I am writing regarding a householder planning application reference: 2024/62/93588/W
Erection of two storey and single storey rear extension at 114 Slaithwaite Road,
Meltham, Holmfirth, HD9 5PW.

Proposed rear/south facing elevation (1:100)

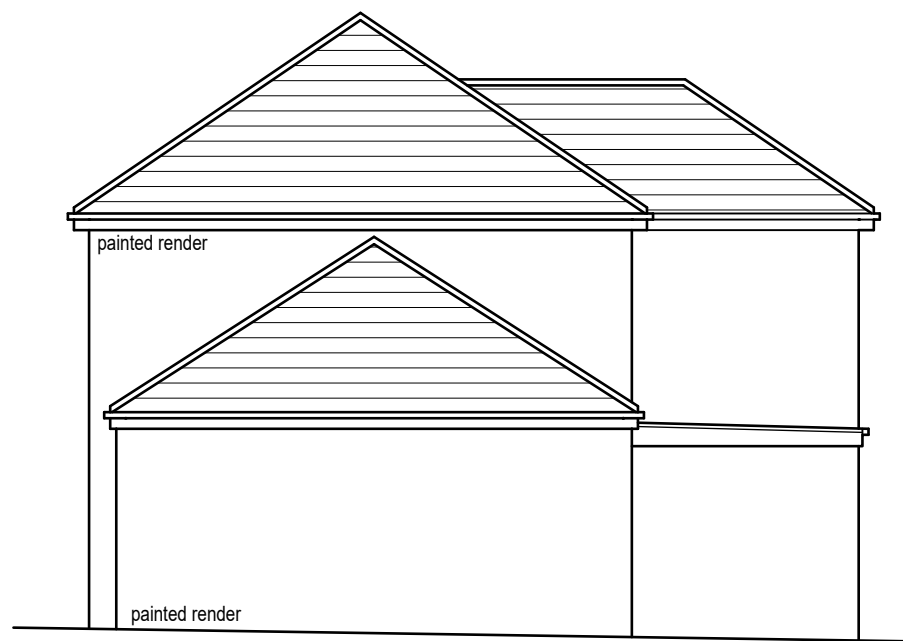
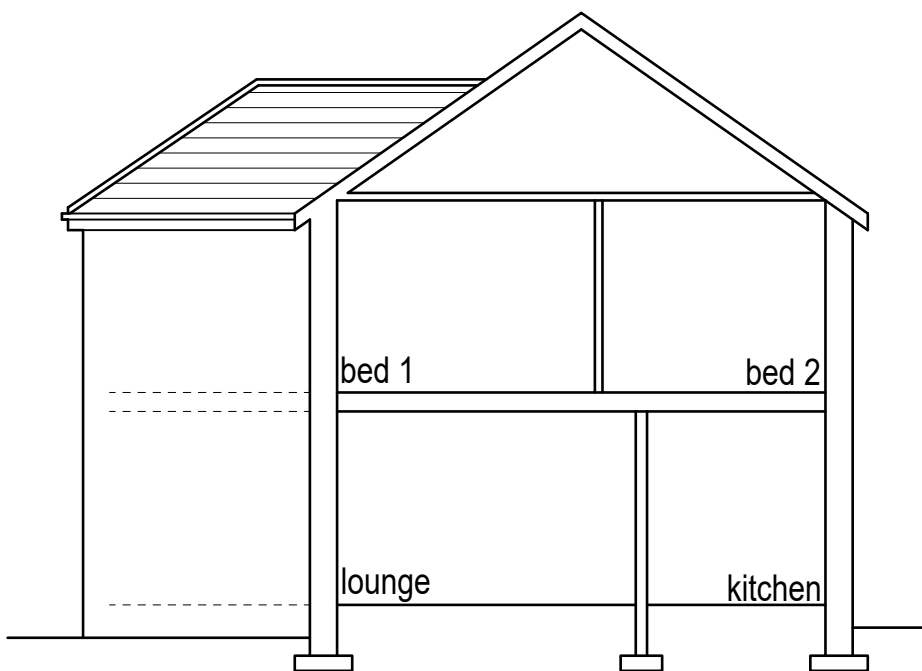
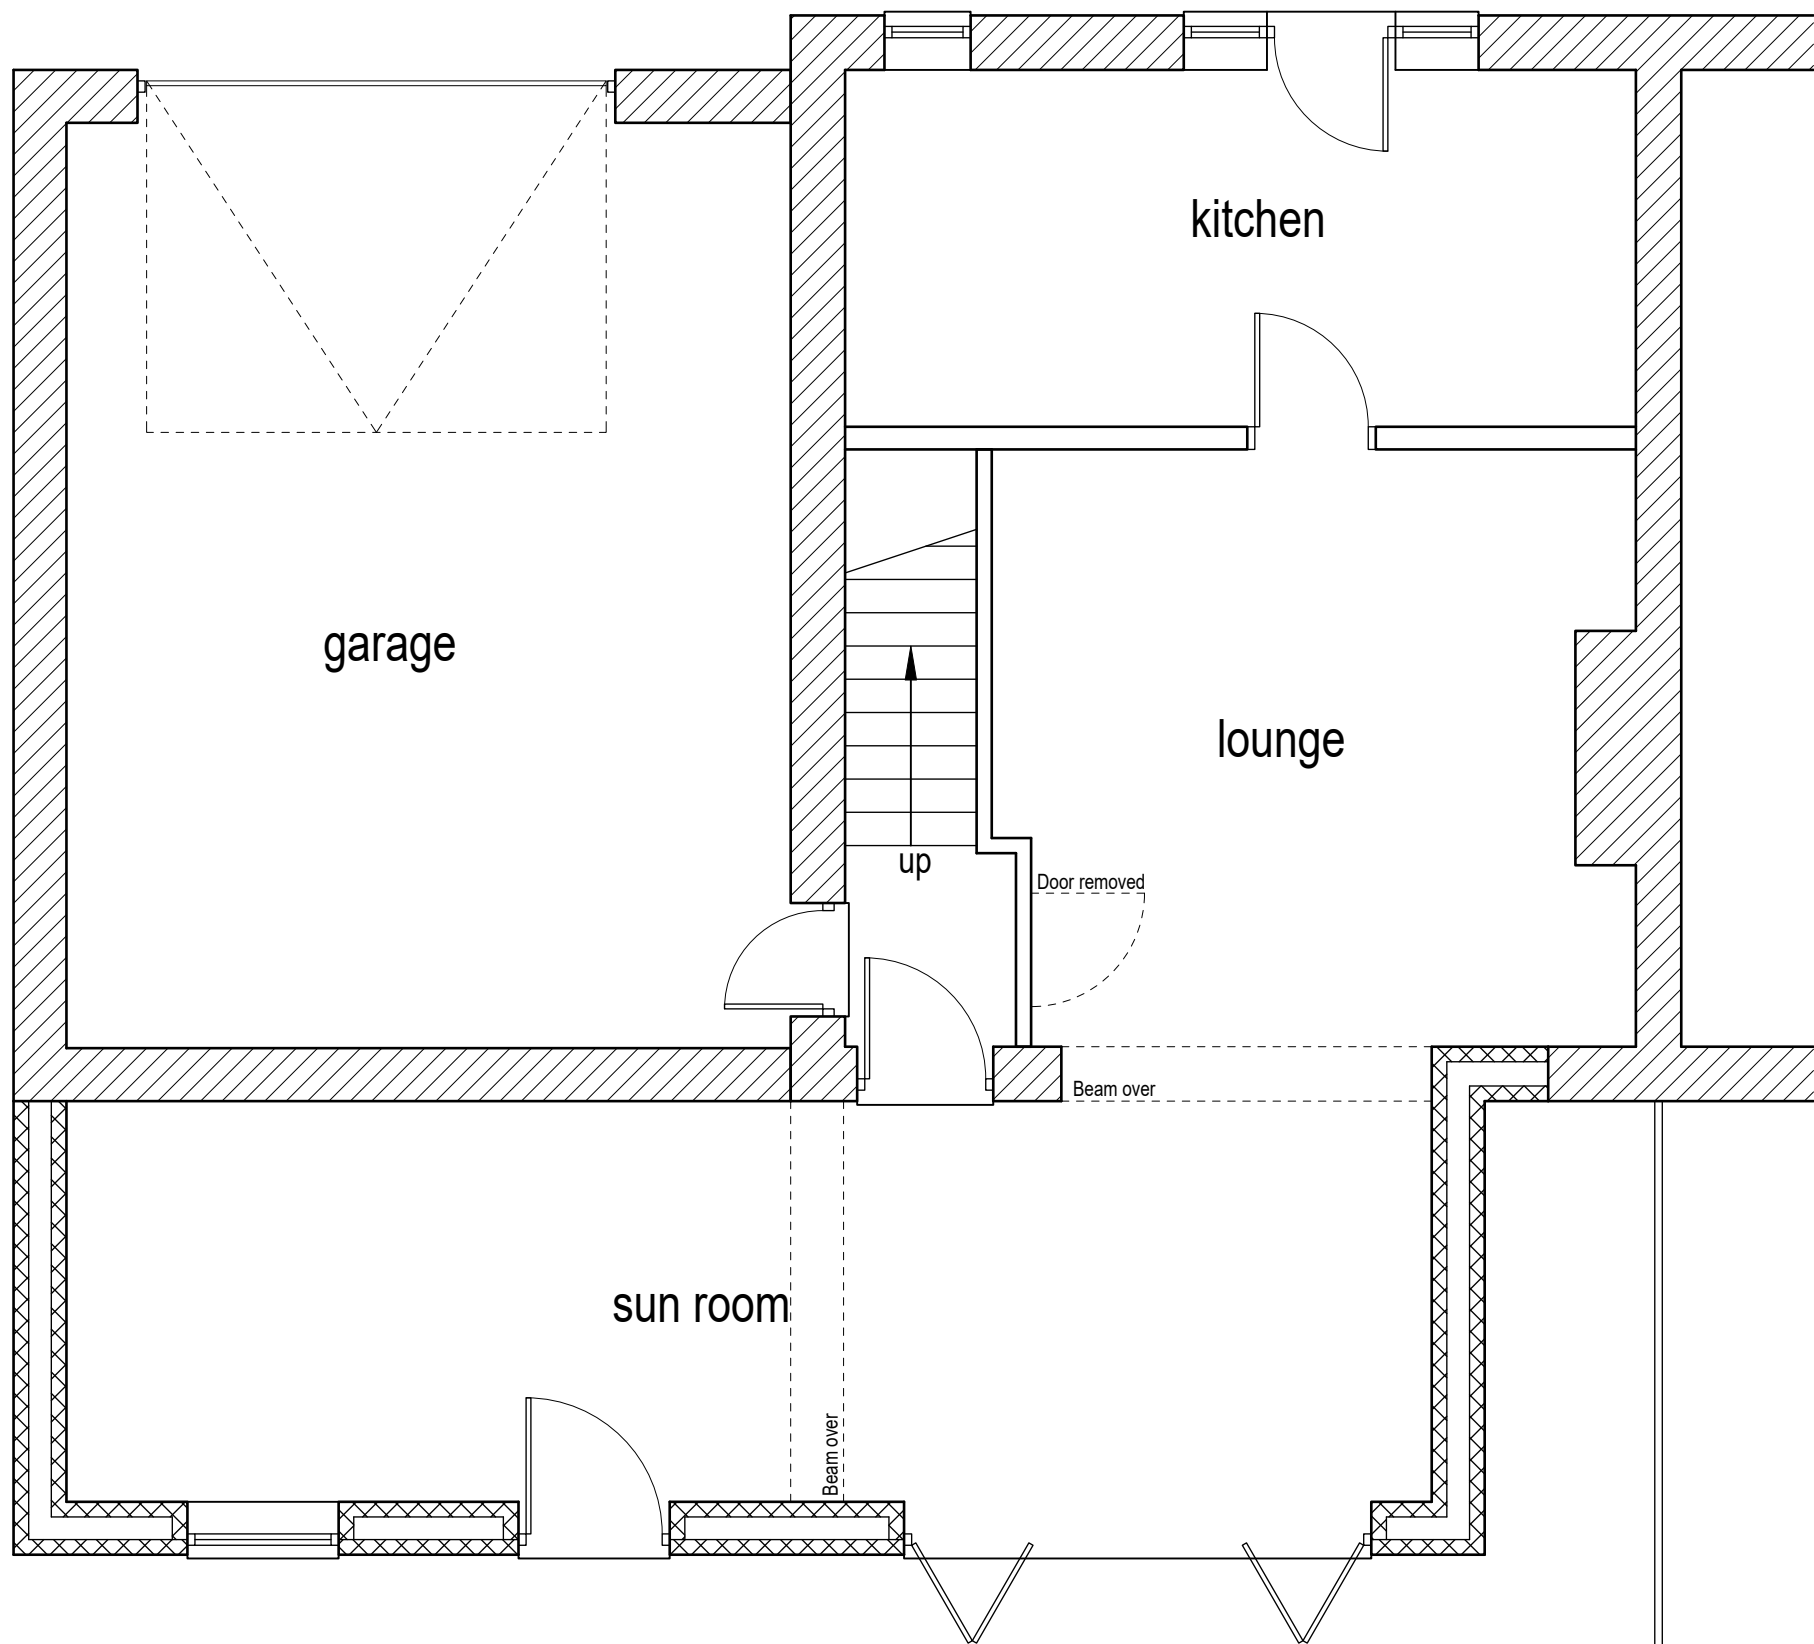
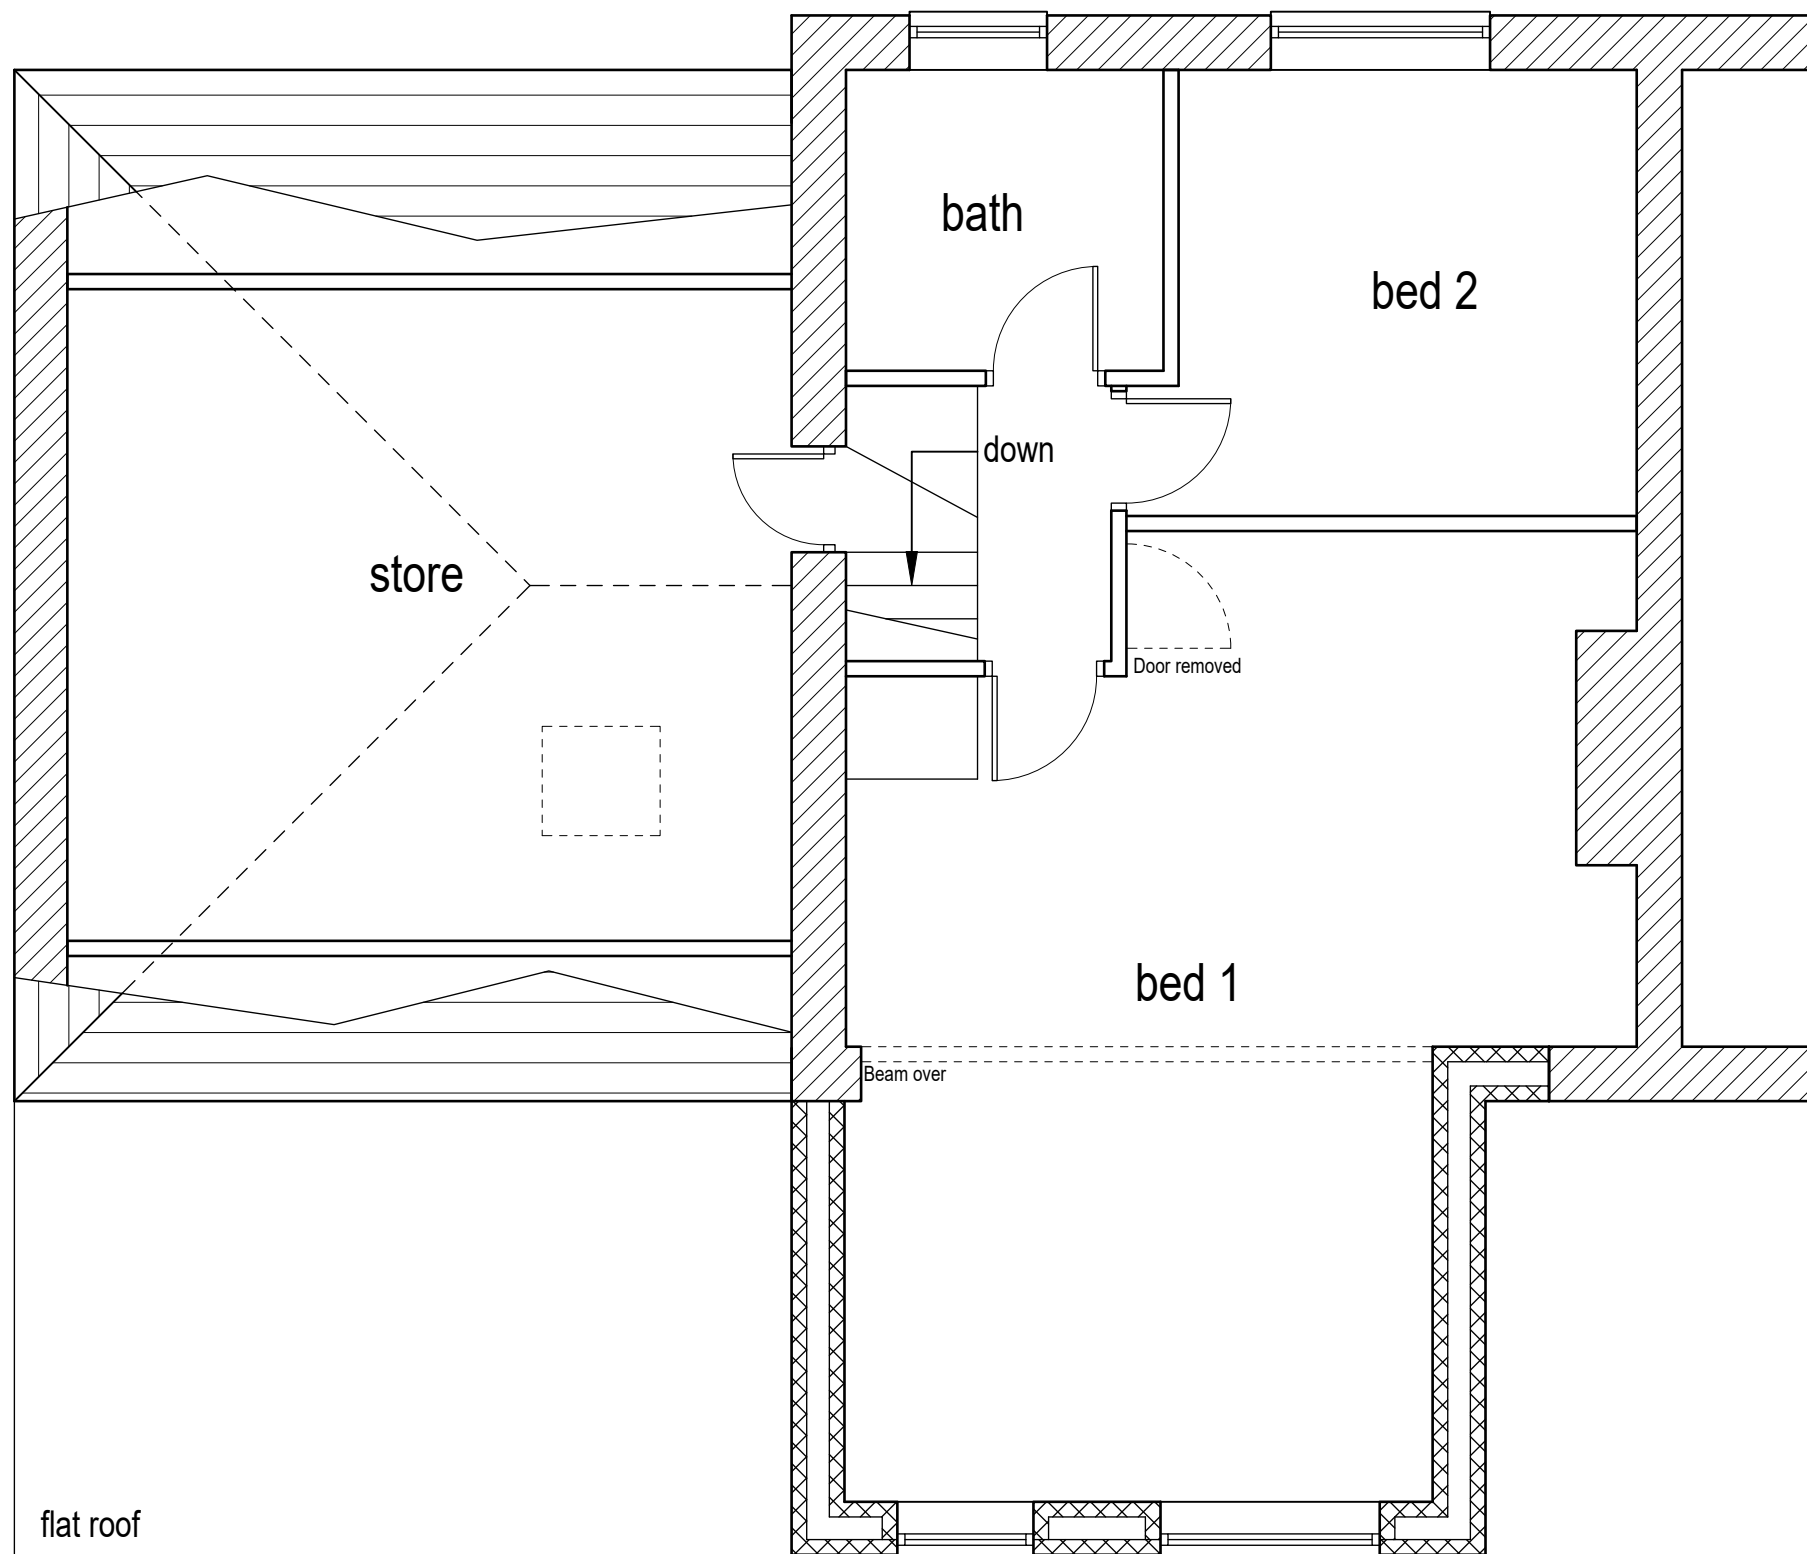
- The submitted drawings don't state how far the extension is set away from the boundary, nor the height of the extensions.
- The 2-storey rear extension is considered overbearing given the distance to my property and most notably adjacent ground and first floor habitable bay windows. We feel this will unreasonably overshadow habitable rooms and private garden areas and will materially affect the amount of natural light currently enjoyed by my property.

- The single storey extension isn't in keeping with the host dwelling (flat roof)
- The extensions appear flush with the host dwelling and not set back therefore not appearing sub-ordinate to the host dwelling.
